Referral Point : Claire Potts / Planning Officer – seeking advice on an application for approval of reserved matters relating to tree protection.

Reference : LU/234/16/RES

Location : Land between the A259 Worthing Road and the East Street/Fitzalan Road roundabout

TPP.3

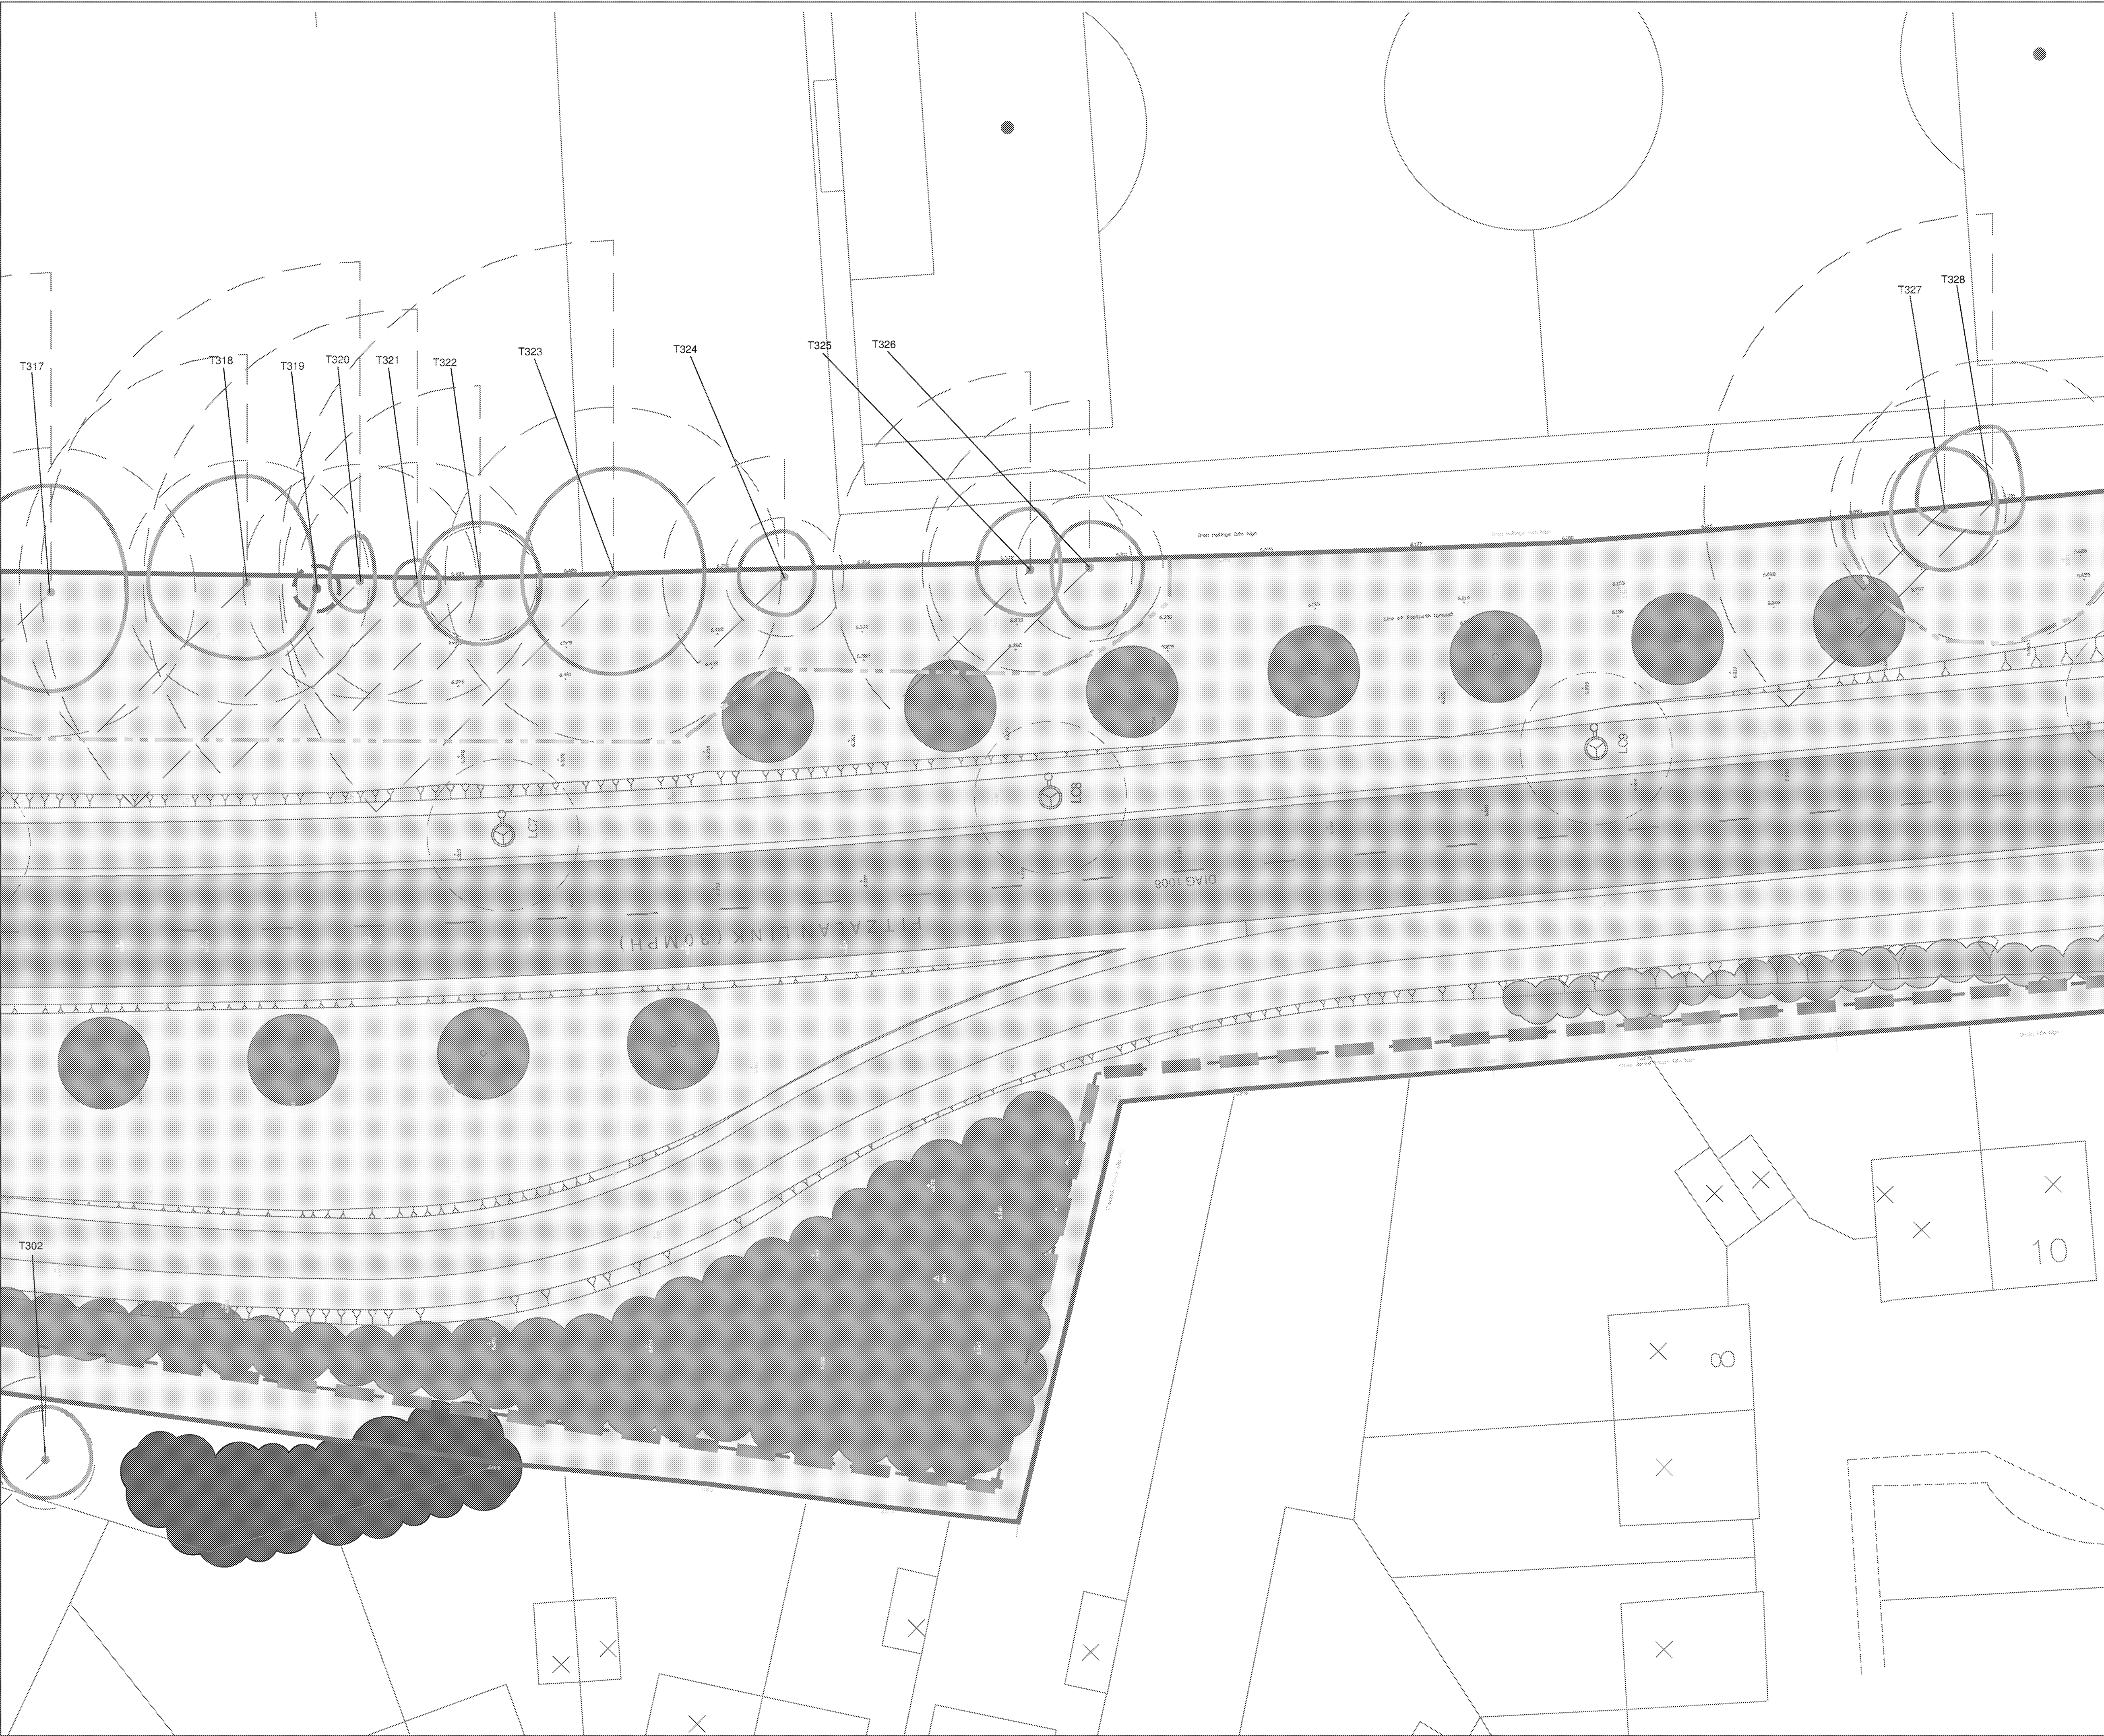
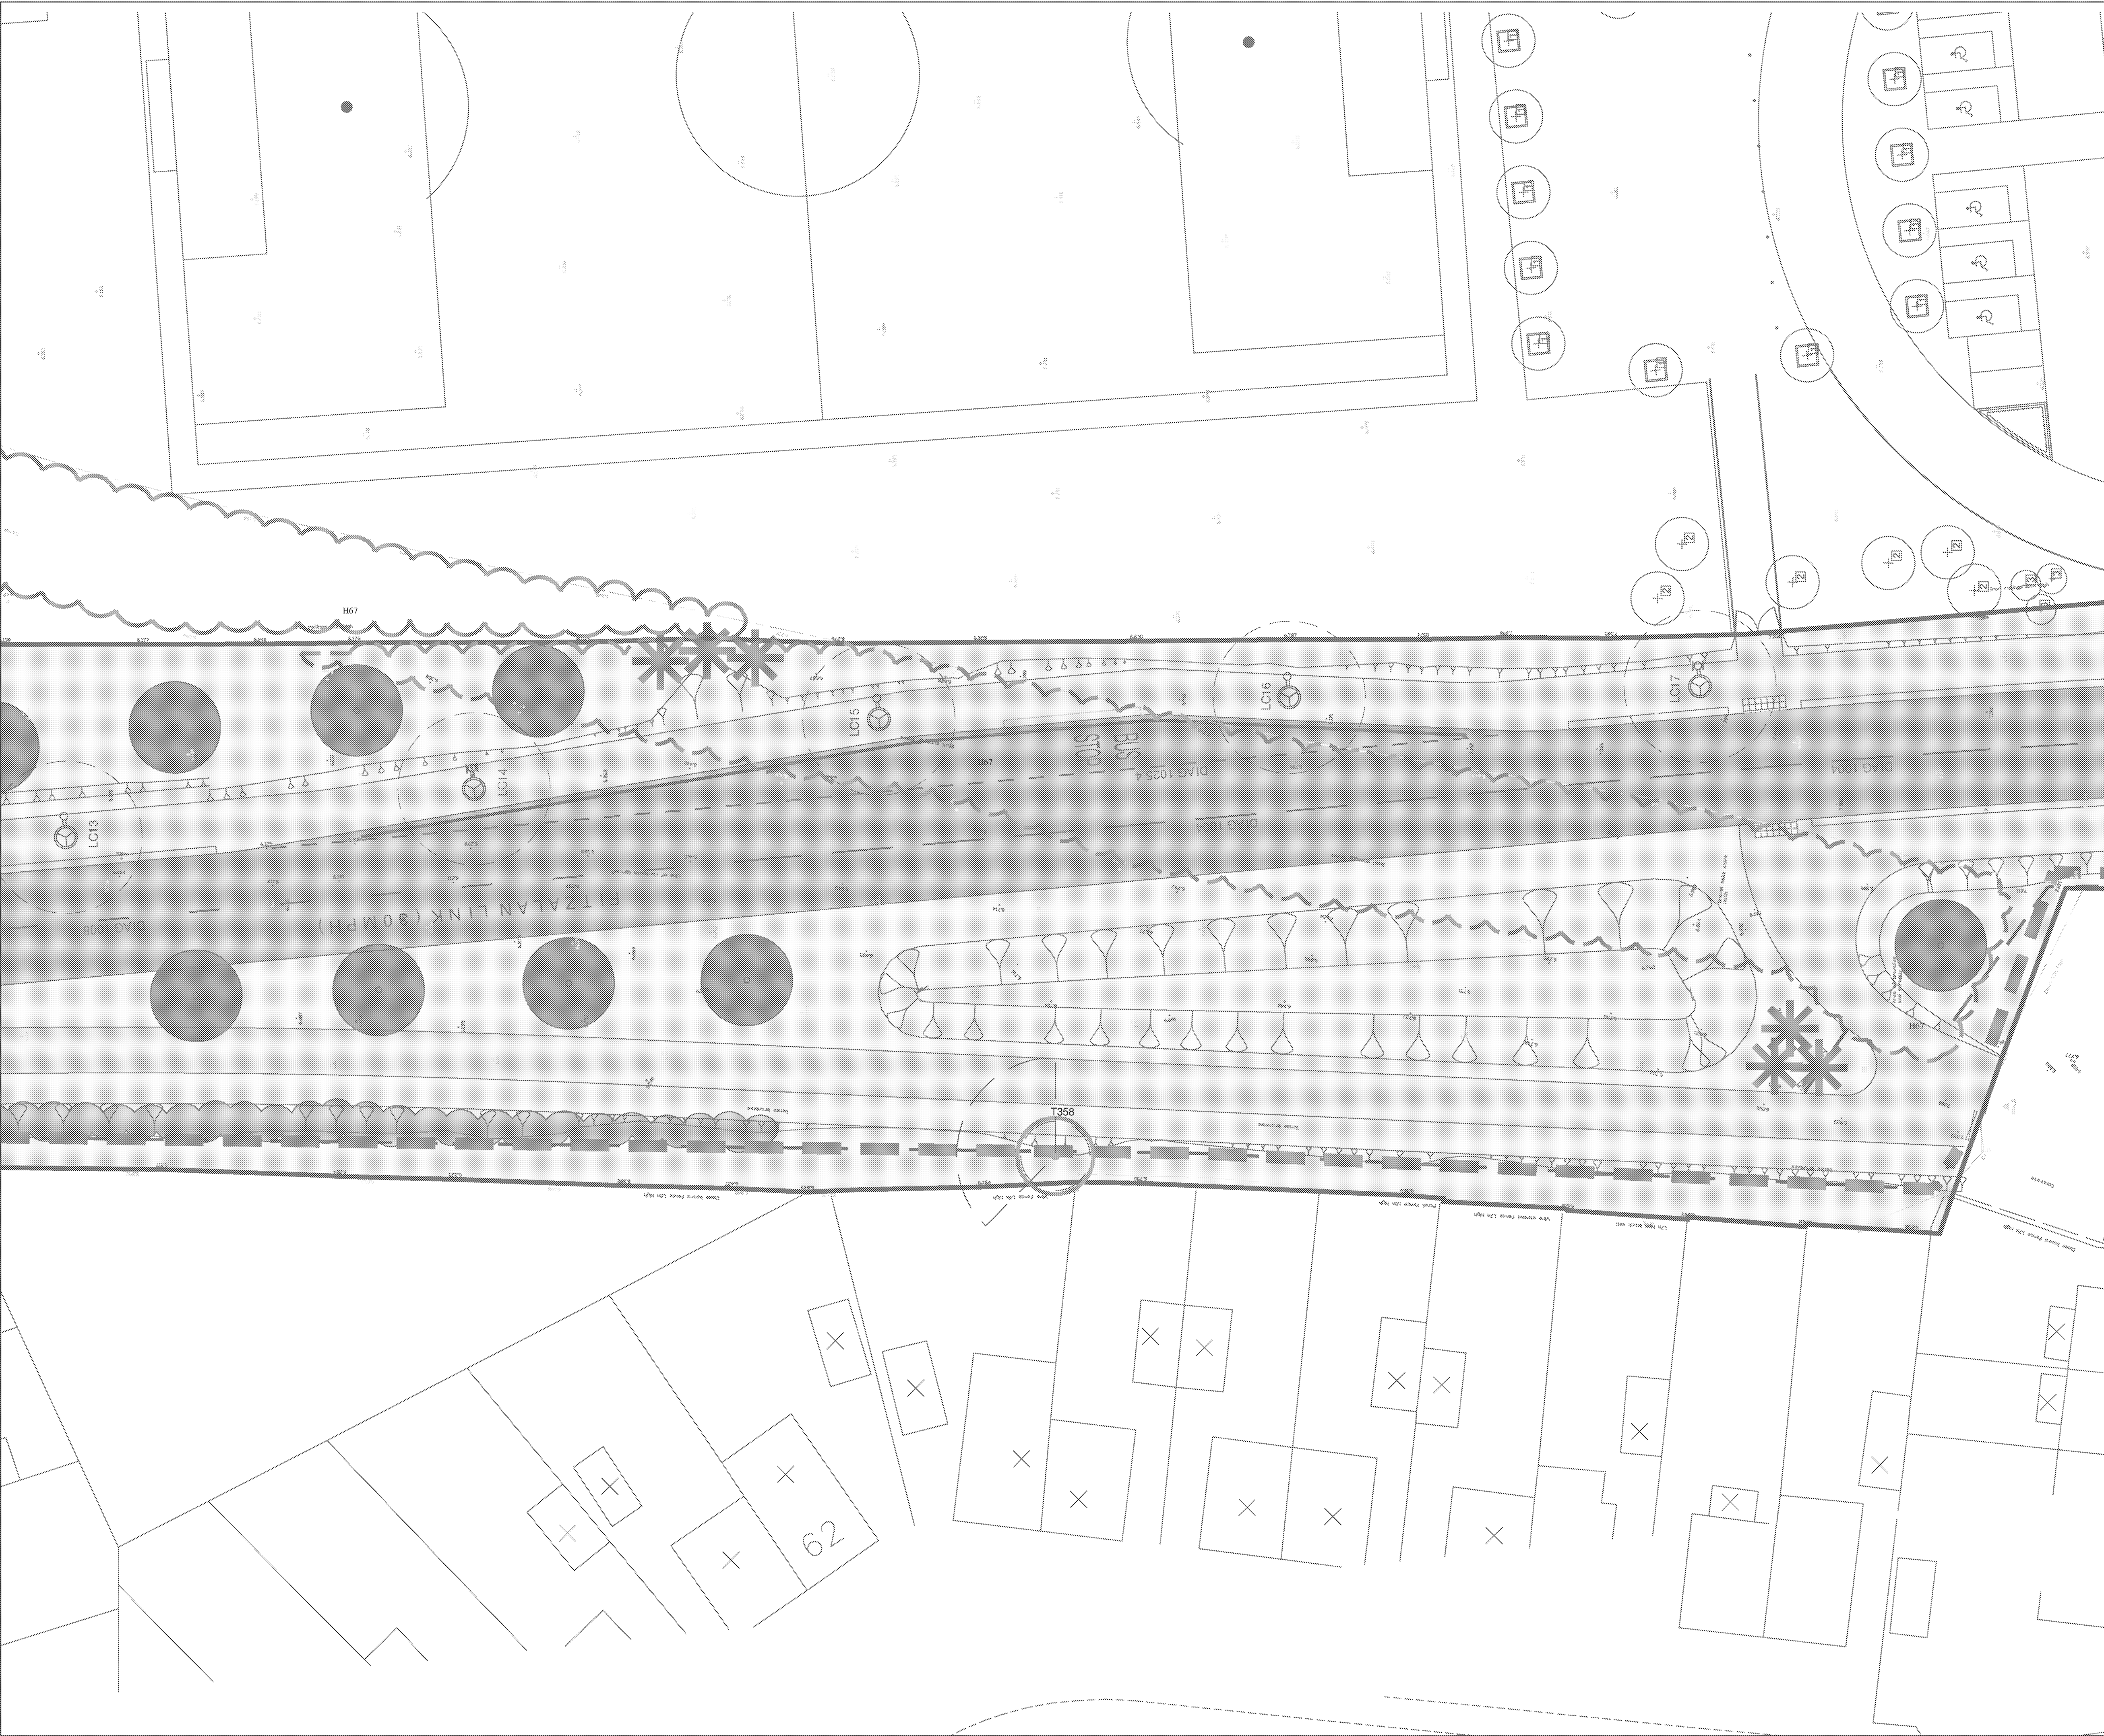
- I walked the route and noted that there are little or no trees or vegetation alongside the western boundary with existing residential development.
- There is however quite a lot of mature and maturing Lombardy Poplars/Hybrid Poplars and Ash trees alongside the eastern boundary with the Academy School grounds which are trees we would wish to see retained and fully protected during the development process.

- These plans show that a full and detailed tree survey and root protection schedule exercise has been undertaken and that protective fencing requirements have been calculated and plotted on the Landscape Plans.

I am happy with the level of Arboricultural input in respect of plans submitted and the levels of tree protection shown will be adequate to ensure that these trees are all retained in a sound and healthy state. Provided that the protective fencing is to Section 6 & Figure 2 standards as prescribed within BS5837:2012.
